Application for a non-material amendment following a grant of planning permission.
Town and Country Planning Act 1990

The installation of 1.no. 21 metre high RT Swann Lattice tower on new concrete base with 6 no. antennas, 2 no. dishes, 4 no. cabinets and ancillary development thereto

Reference number: APP/C3105/W/17/3174363

Drawing Title:
PROPOSED SOUTH EAST ELEVATION

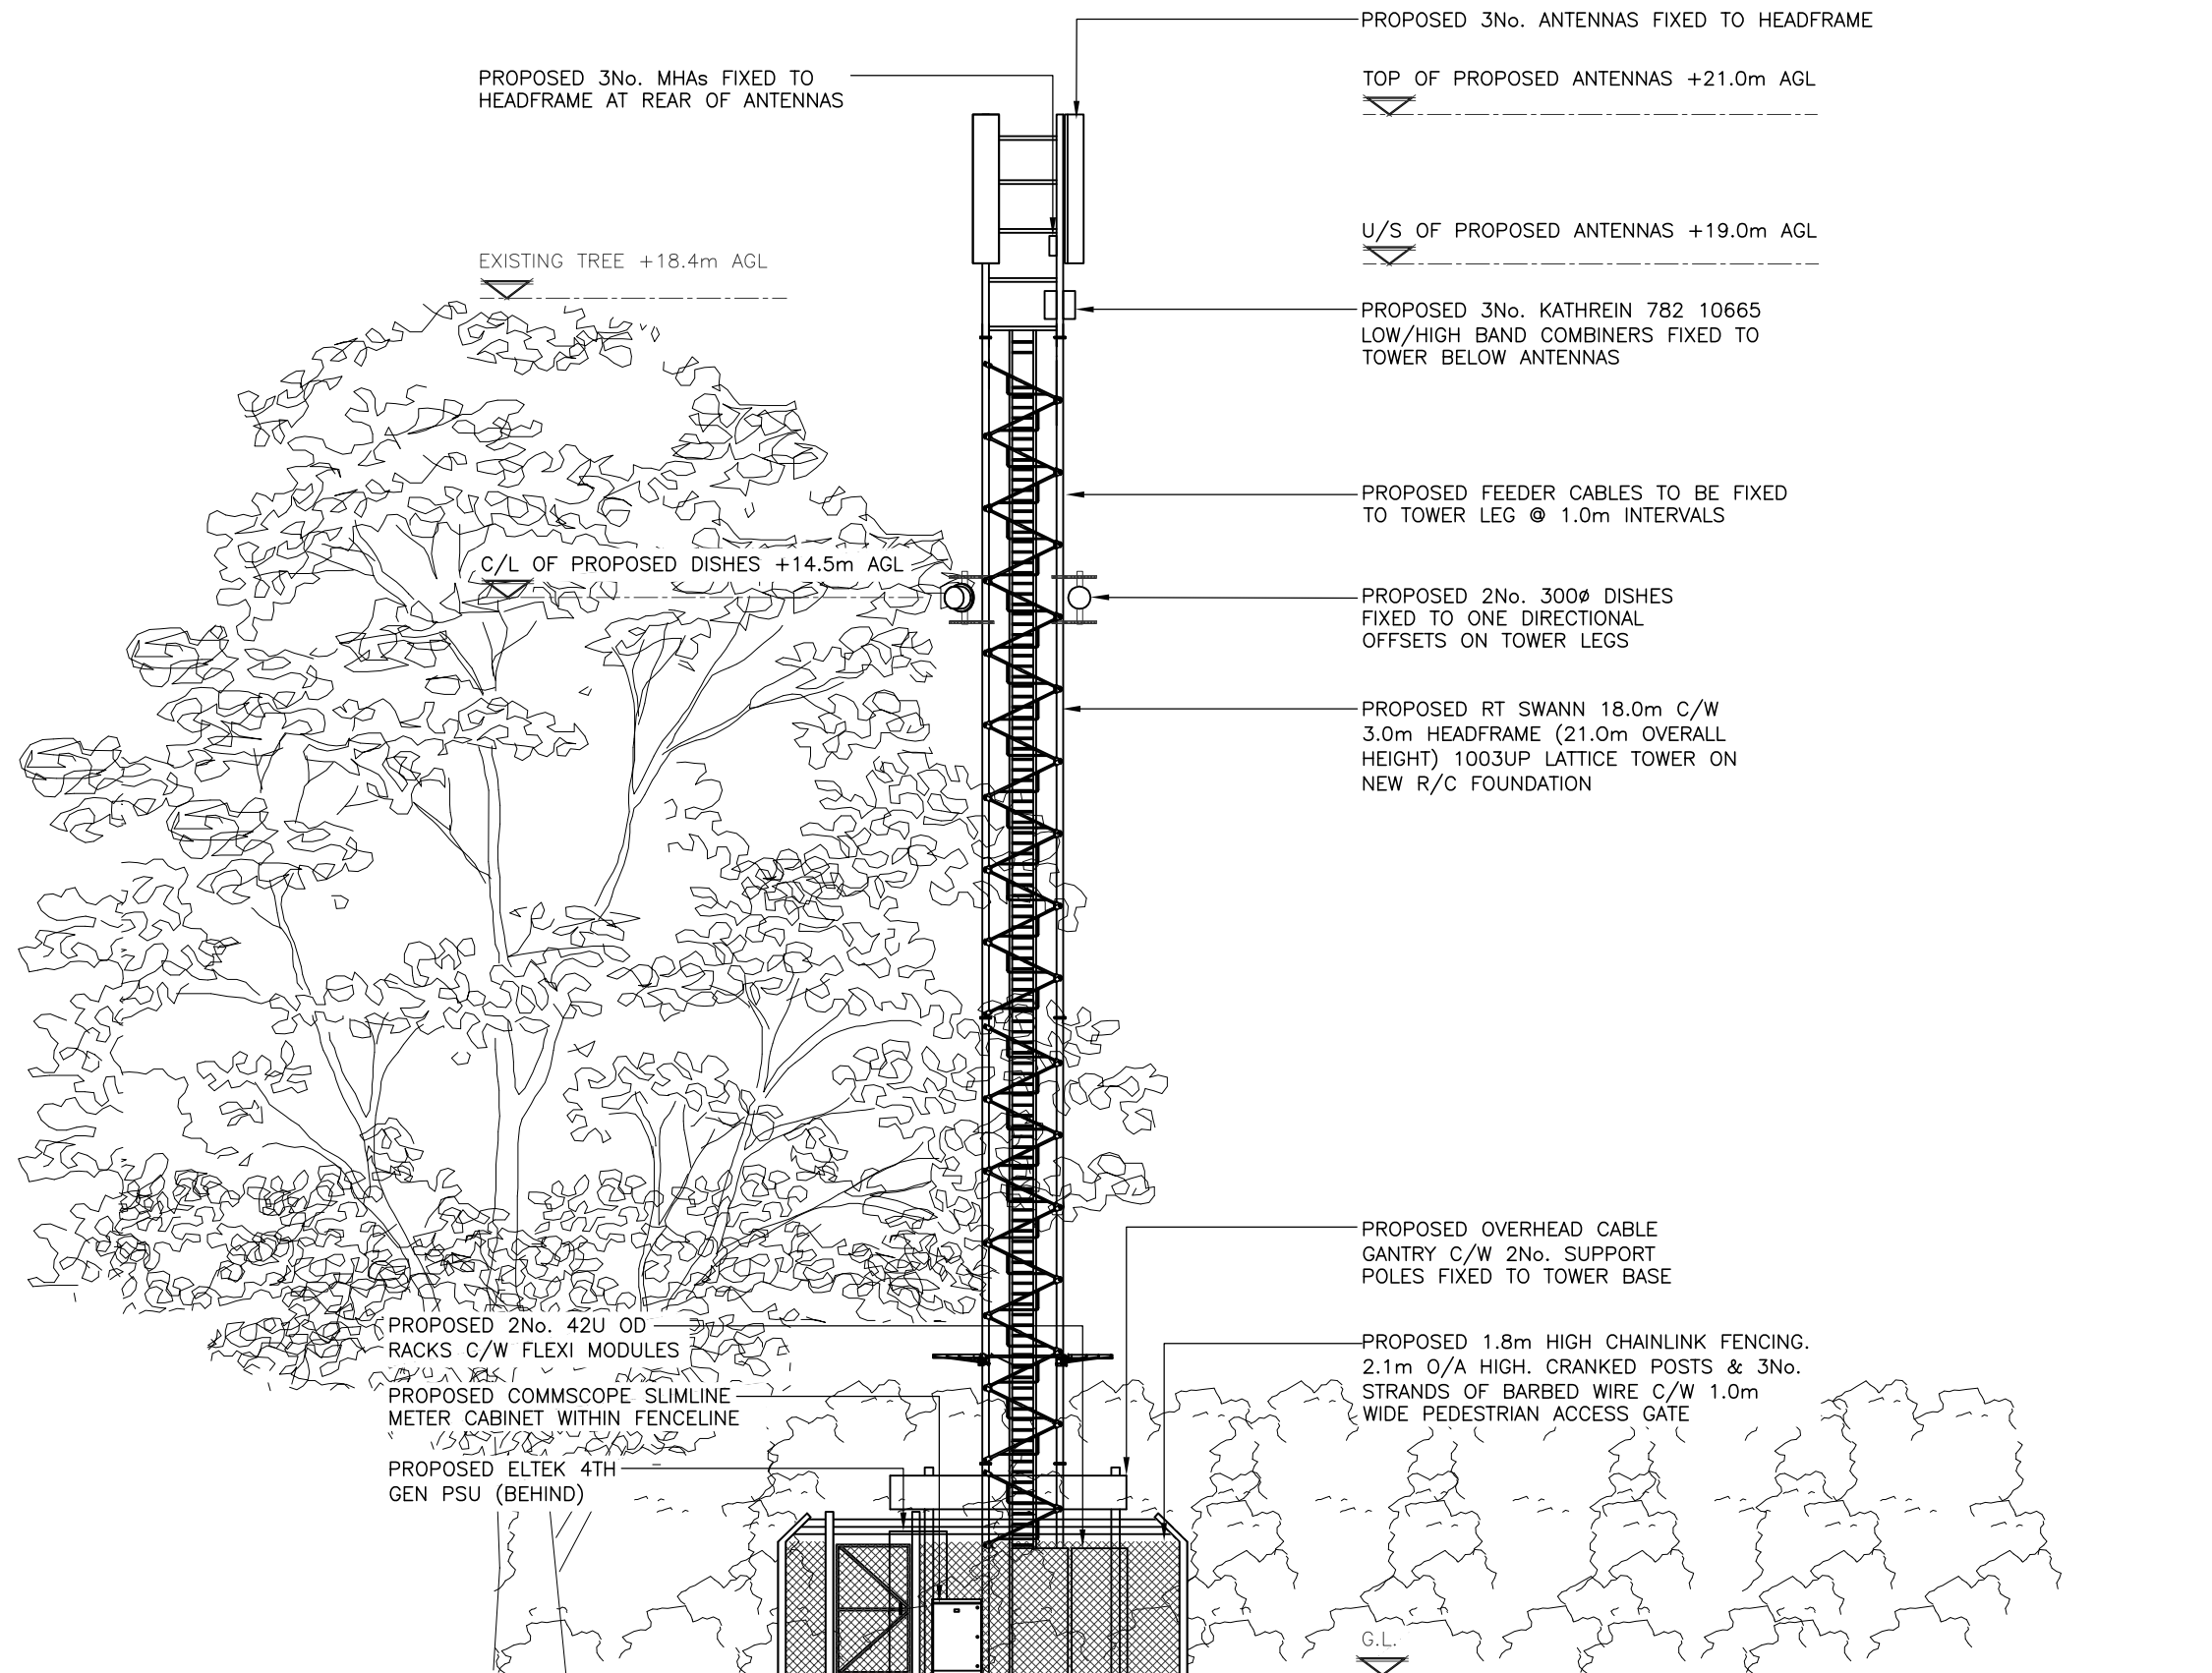
The proposal is that the 21m lattice tower will have only 3 antennas attached initially, rather than the 6 approved on the application. My client would like to make a minor amendment to the drawings to reflect 3 x antennas and include another 3 for future expansion.

For the site to meet Beacon 2 compliance the antenna needs to change from 6 x Commscope 10R3 antennas to 3 x Commscope 11R antennas
